From: Amanda Scholes on behalf of Planning.Responses
Sent: 11 January 2021 10:23
To: Planning Scanning
Subject: FW: Planning Consultation on: A/201/20/DOC

Application No: A/201/20/DOC
Site Address: Land South of Water Lane Angmering
Description of Works: Approval of details reserved by condition imposed under ref A/99/17/OUT relating to Condition Nos 11 - highways, 12 - refuse & recycling bins, 13 - parking, 15 - fire hydrants, 29 - contamination, 31 - verification report, 32 - electric vehicle charging strategy and 33 - external lighting

Condition 33 Lighting

**RESERVED MATTERS
GENERAL ARRANGEMENT
SHEET 2**

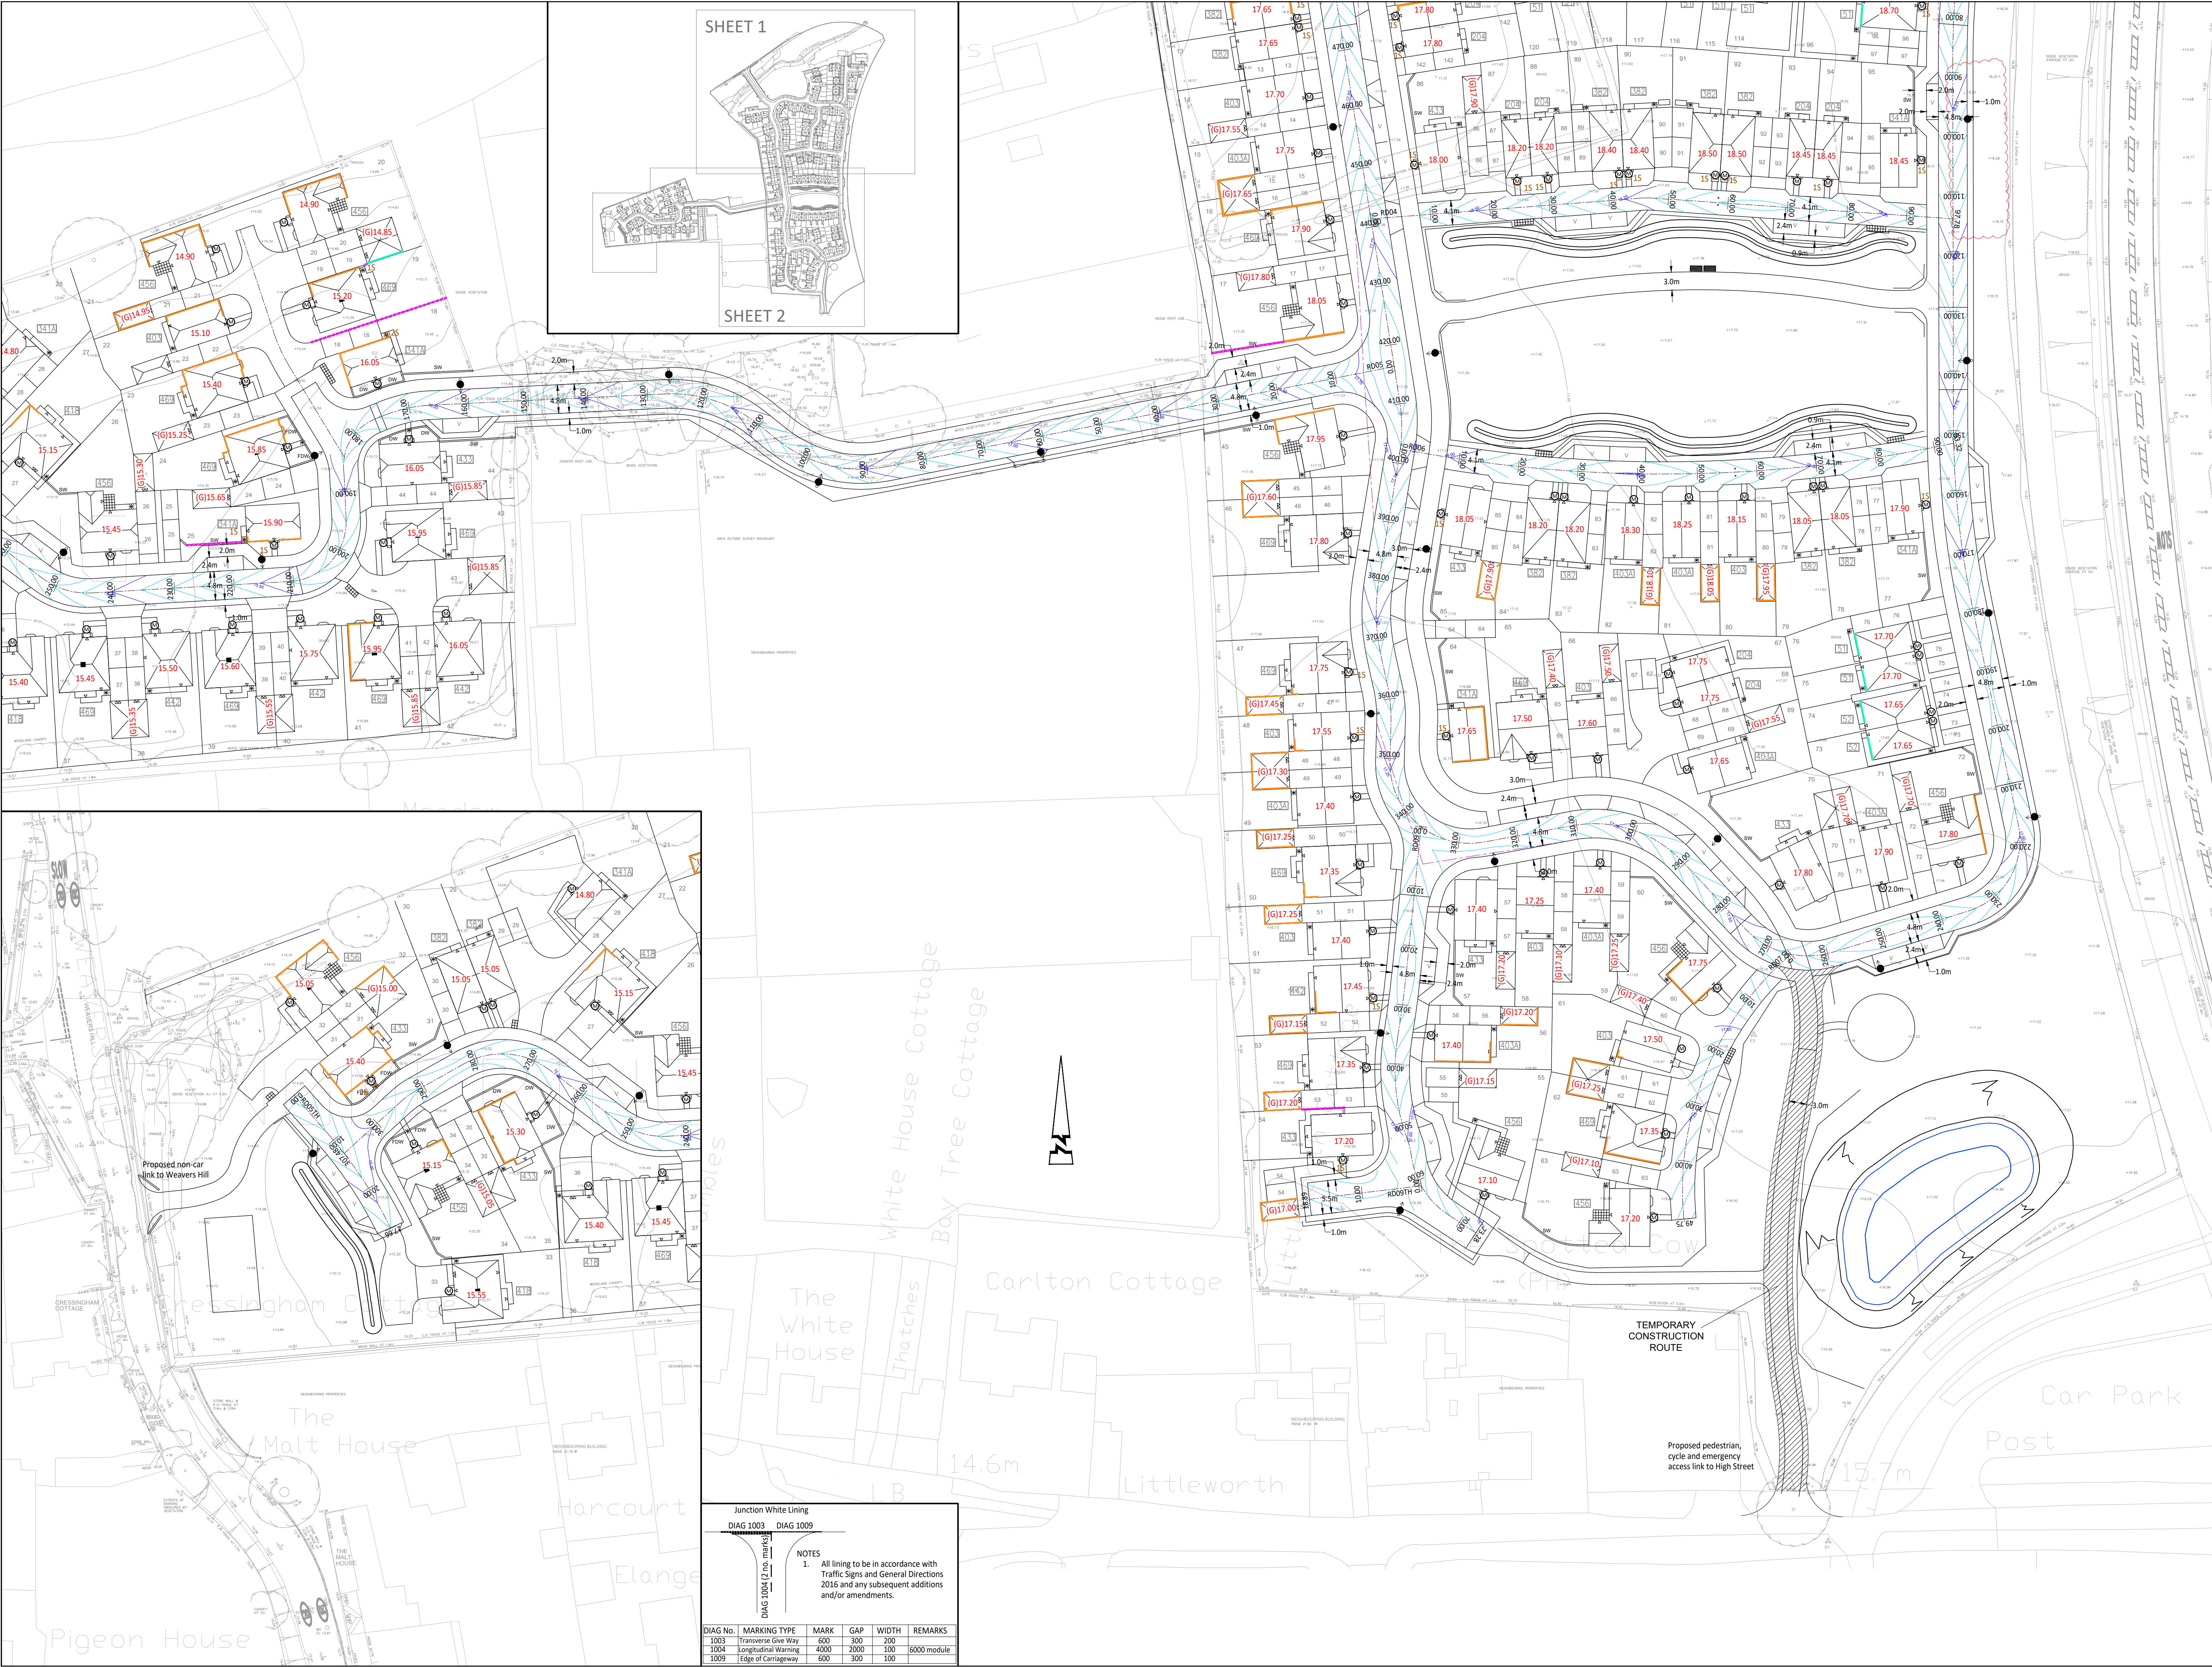
Please can further information relating to the lighting scheme onsite be submitted with this application, including the details of the chosen light fittings for both external site lighting but also the external lighting on each property along with their locations. The information provided on the general arrangement sheets is not sufficient. The application should be aware that the lighting will need to ensure there is no light spill towards any roofs, hedgerows and trees as this would disturb any foraging or roosting bats.
